WOODMOOR WATER & SANITATION DISTRICT NO. 1

HWY 105 UTILITY RELOCATION - PHASE B

GRADING AND EROSION CONTROL PLAN

EPC STORMWATER REVIEW COMMENTS
IN ORANGE BOXES WITH BLACK TEXT

SHEET NO.
CE1.0

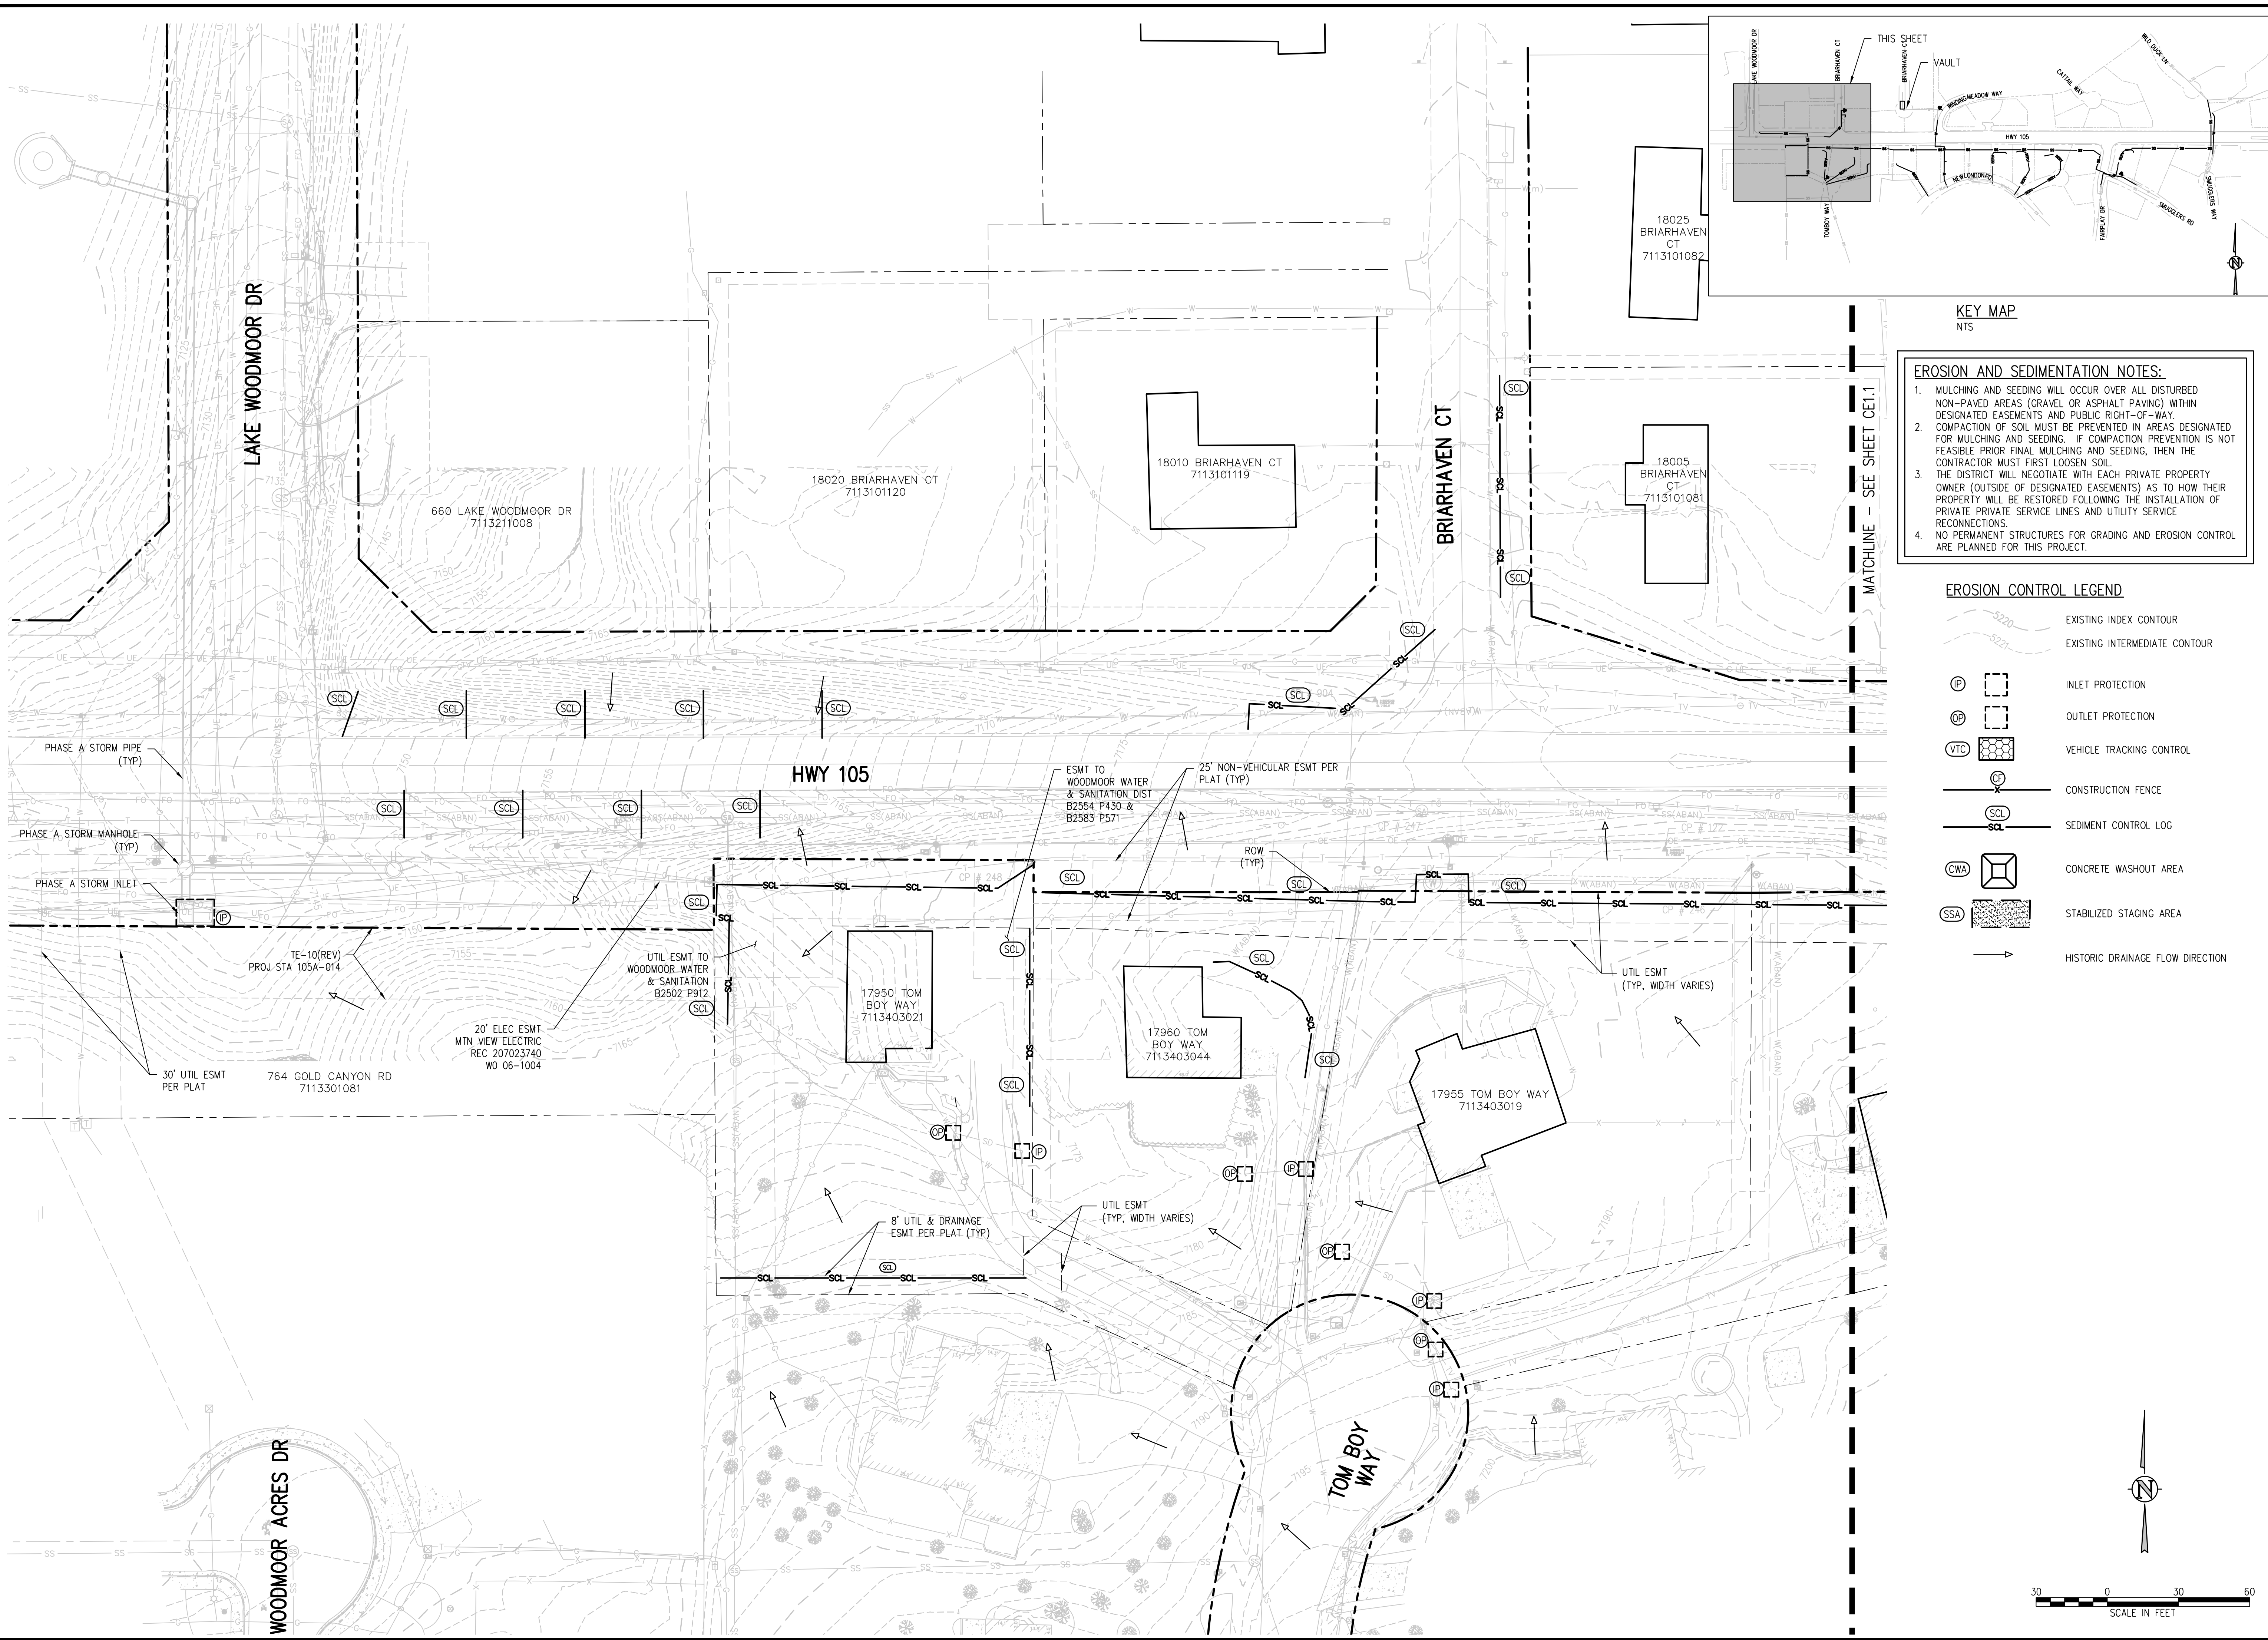
Item 1. Add Qualified Stormwater Manager and Contractor information to cover/title sheet. If unknown, add a placeholder to be updated prior to the pre-construction meeting.
